File Name: OES_SEPT4_ISH2_PT5.mp4

FULL TRANSCRIPT (with timecode)

Okay. It's now a 2:15 and it's time for us to resume this issue. Specific hearing. Thank you. So, um, can I just check that the recording and the live streams recommenced? Yep. Thank you very much. So. And again, also just check that those who are online can see and hear as clearly. Super. Thank you. All right. We'll move then on to um the agenda on covering biodiversity and or ecology.

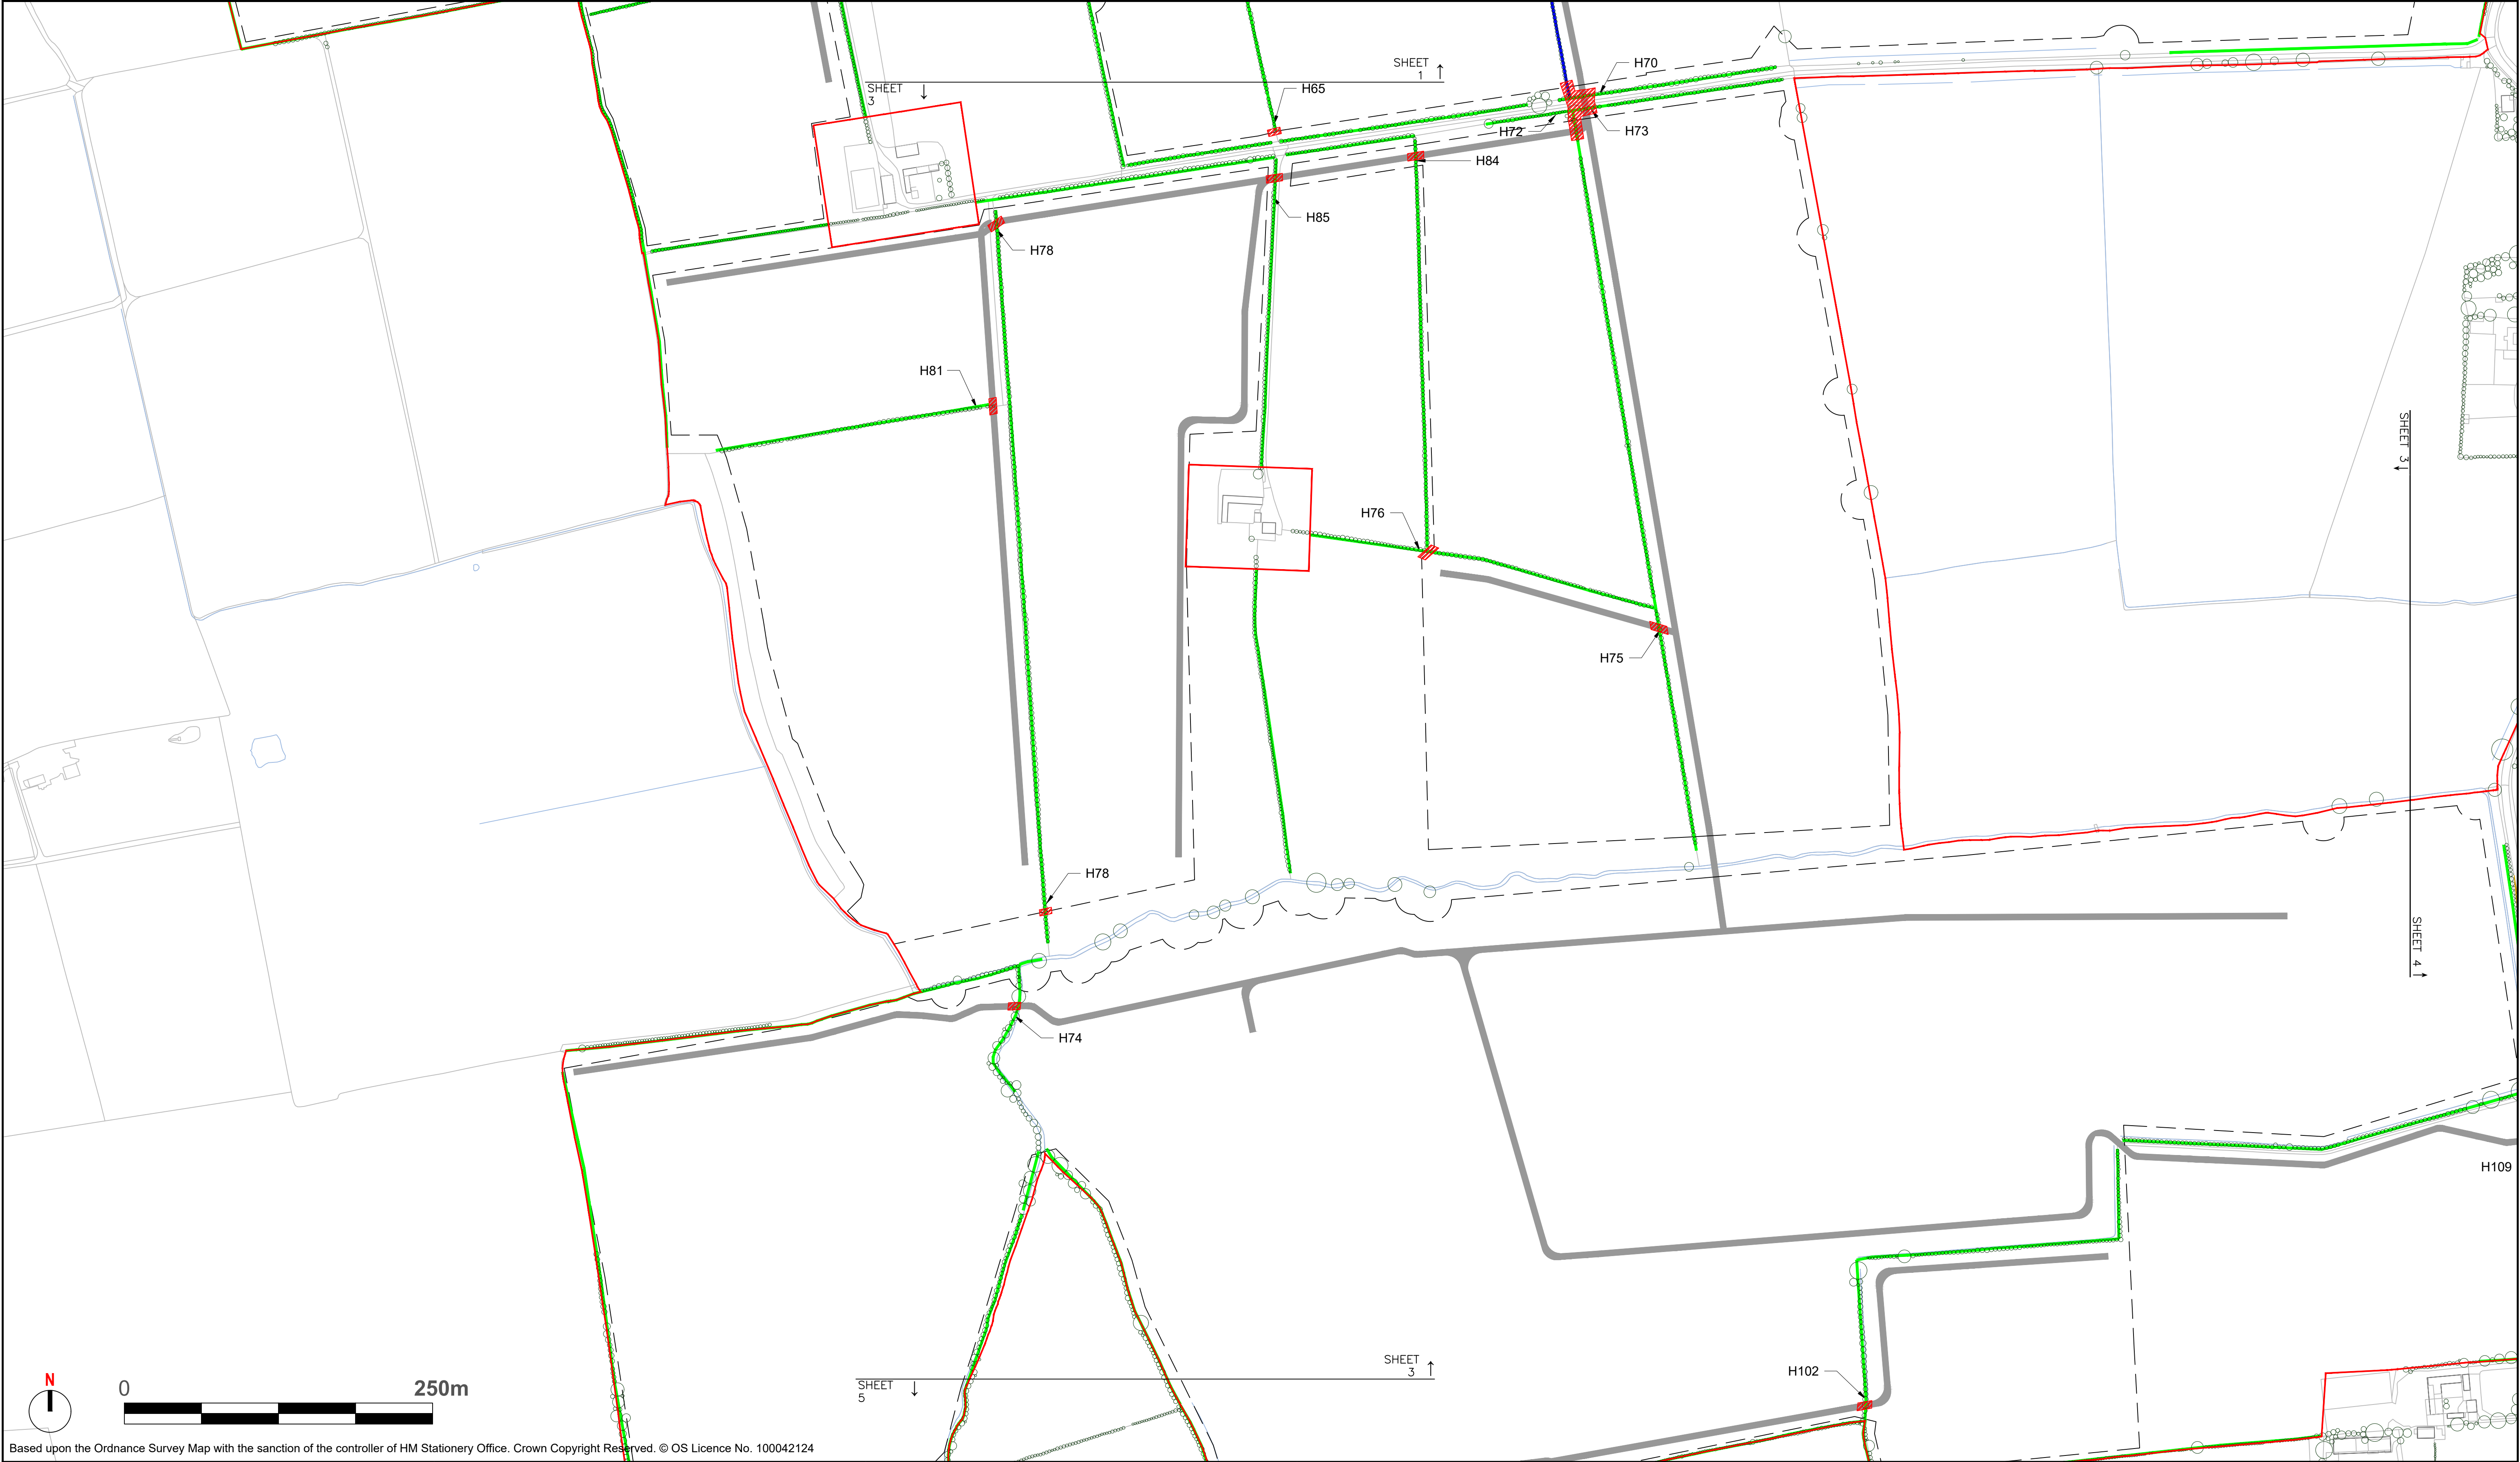
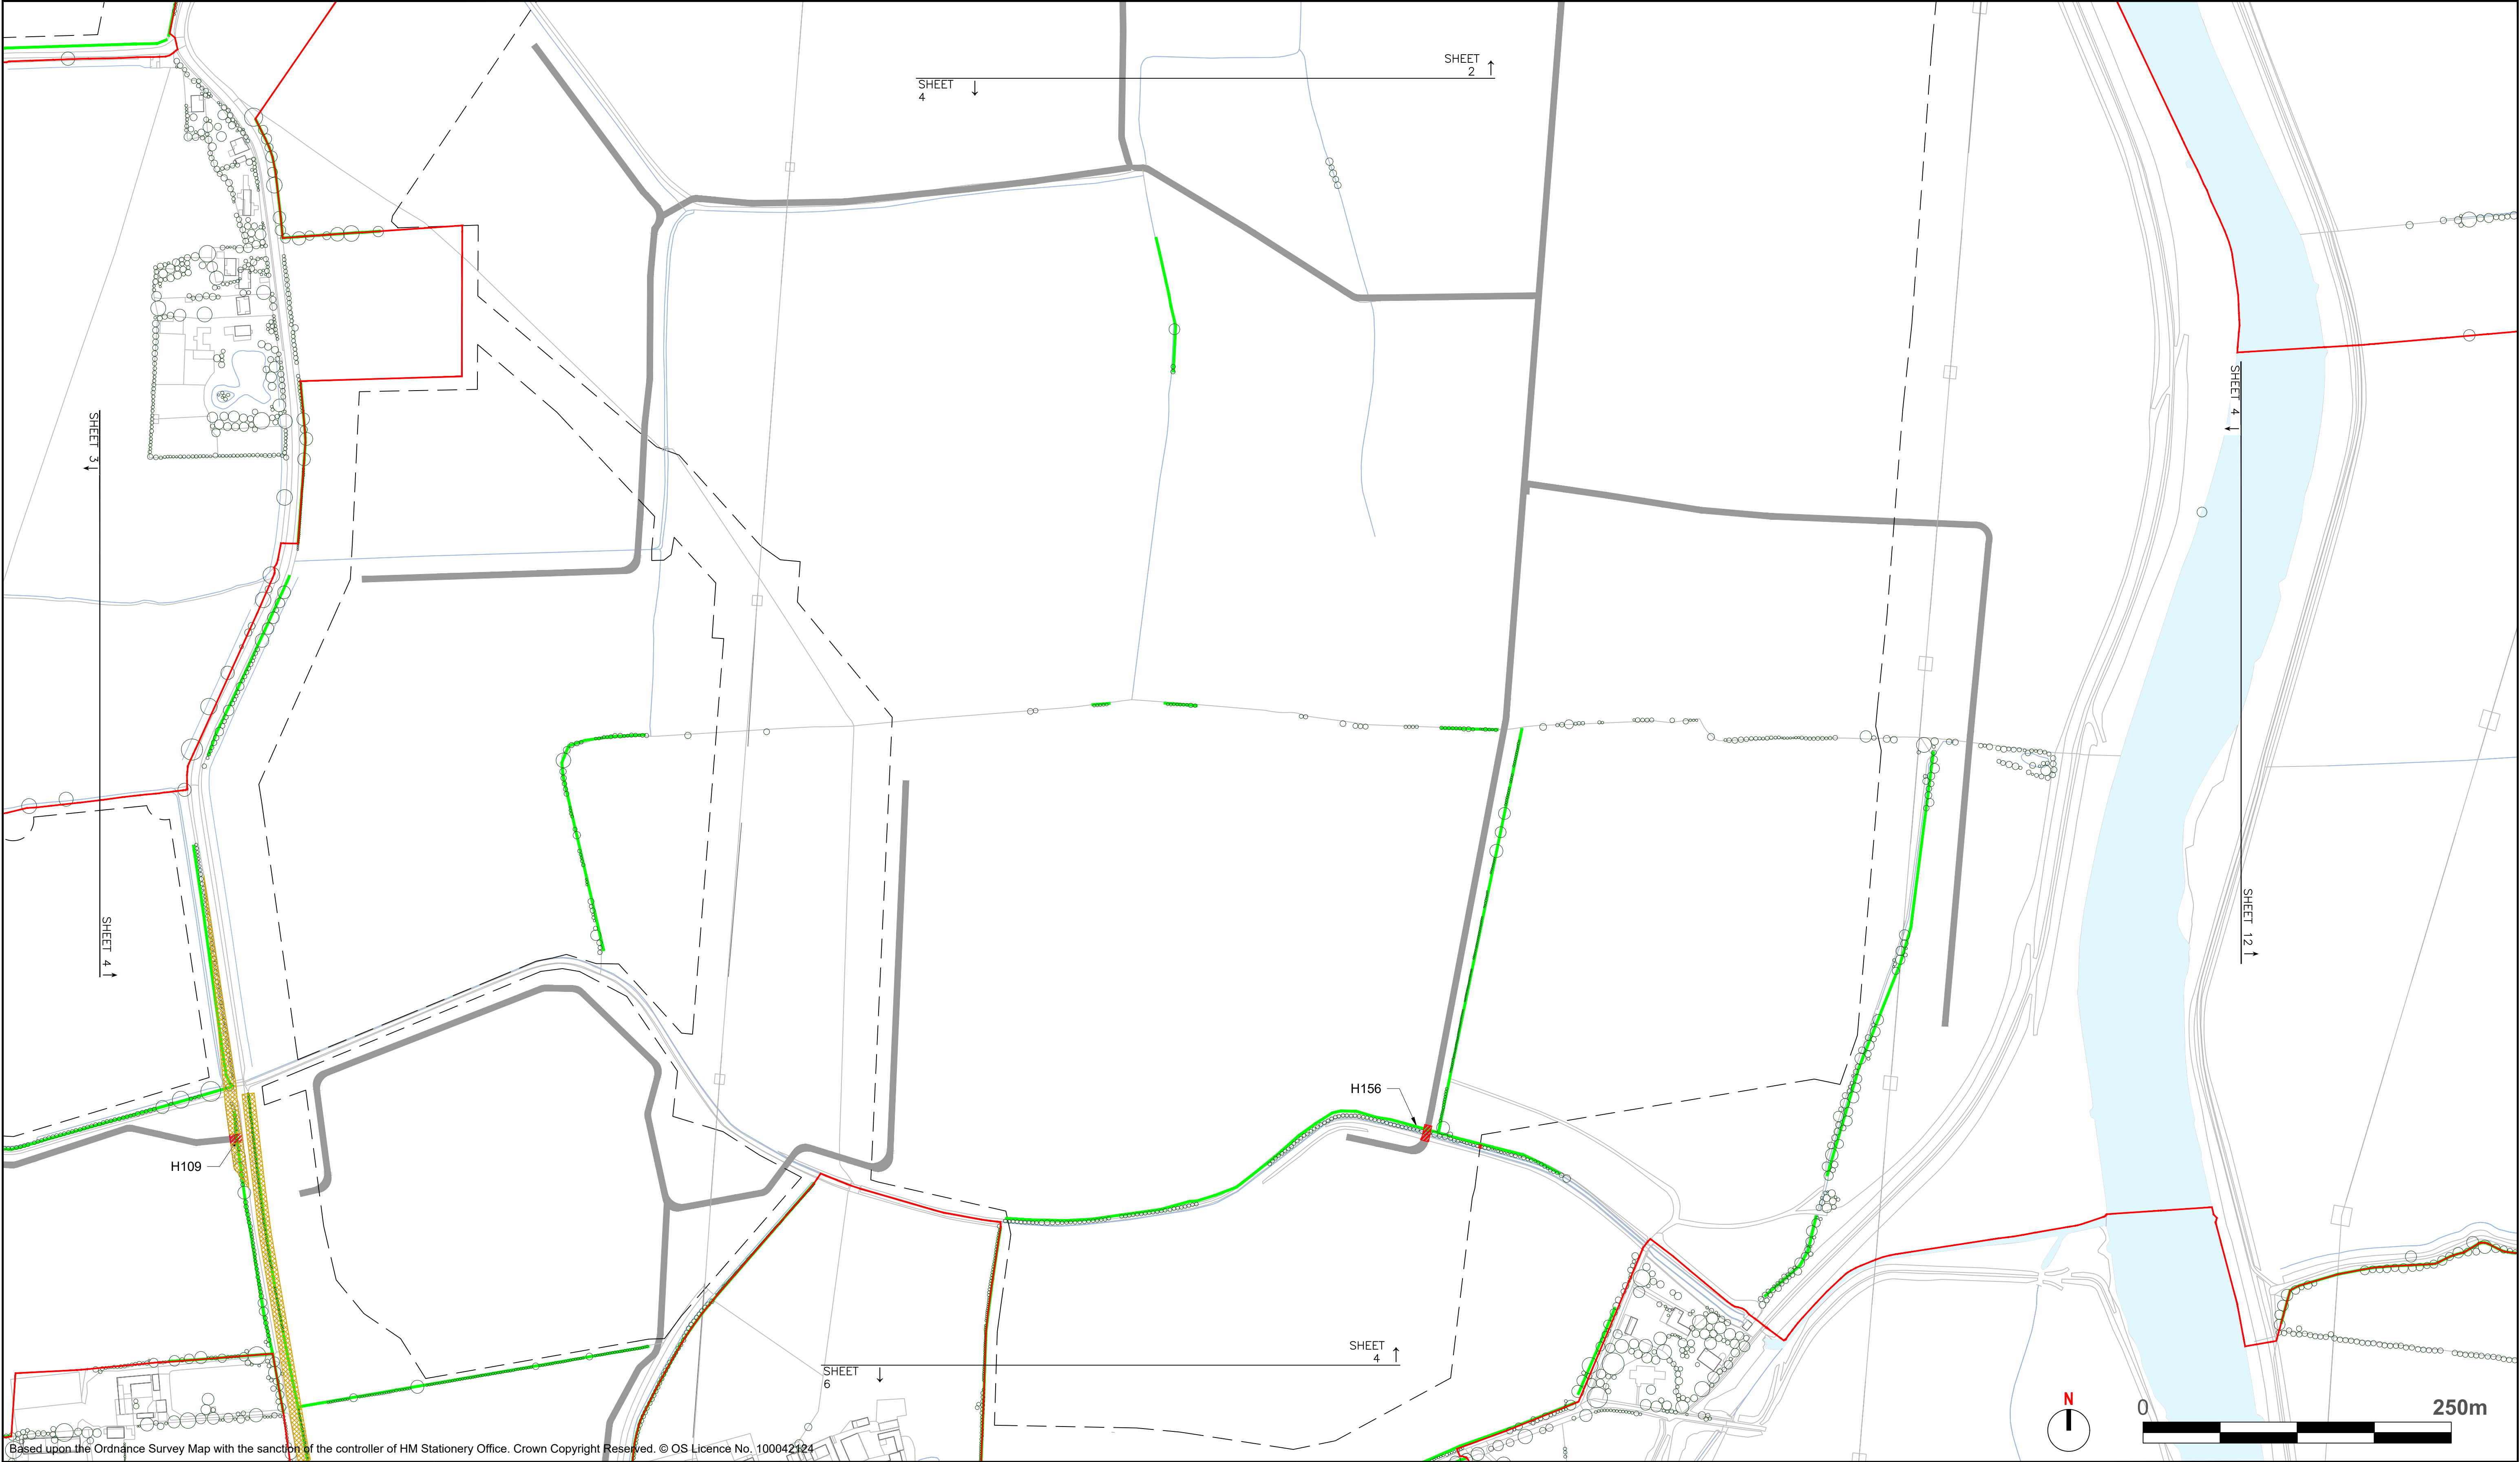
Excuse me. Uh, just really seeking additional clarification from the applicant. How your approach to a animal movement across the site, uh, is to be managed. And what elements of the DCO secure that planet approach? Now we note the response to our written question. 7.0 0.1 um, and you refer us to the appendix C of the vegetation removal plans of the Outline Outline Landscape and Ecology Management Plan, which is Rep 1053.

When you look at each of the sheets in in detail, I think you can see the proposed fence lines. But what it's very difficult to navigate through is where the gaps align, because you can't do it as a whole. So just as a simple request, is it possible to provide in a similar way to the illustrative master plan, a plan showing the route through the site that you anticipate animals are going to be able to follow so that we can see and understand more readily the connectivity across the site as a whole.

Amy Rhodes. Nottinghamshire County Council. My only query would be with the fence locations that there is at the very edges of the fence, to buy any hedgerows to keep that linear connectivity and where animals will pass is that there are gaps in each of the edges and that's it. Thank you.

The very edge of the fetch. So if you've got a fence and it's next to a hedgerow, um, to keep the gaps open next to the hedge, because a lot of animals would use a hedge to get up and down for commuting. So it's just to keep that connectivity across the site by using the hedgerows and then making sure there's gaps in the fences for them to continue that connectivity. That makes sense. Sorry, not very technical.

Allen Kirby, on behalf of the applicant. Um. Simple answer is yes. Um, what we'll try and do is highlight areas within and outside of a fence line. Um, so it's quite

part of the Countryside Stewardship. It has a prescription. Um, the only difference here is on request from one of the local authorities that we don't have the gate. We simply have a framed entrance to allow things to move in and out. So it would just be fitted to the standard wire mesh, um, uh, deer fencing. So the fencing as described in chapter five. And we saw on some of the visualisations yesterday, um, it would be that type of fence, except it would have small gaps around every 150m, as described in the environmental measure.

No, no. That's fine. Um. It's helpful. Thank you. And again, are you able to confirm that? that's the intention. So Alan Kirby, on behalf of the applicant. So the final design would be, um, uh, described in the, uh, the landscape and Ecology Management plan when it's been detailed. Um, at deadline two, the Olymp was updated um, in section seven to describe um working in partnership with local authorities and uh, Natural England and others to have a steering group in terms of informing those things.

So the actual, um, alignment location of those gaps would be discussed and agreed at the time. And so there's no issue with putting those in in places as, as um, Notts County Council were just saying there along hedgerows.
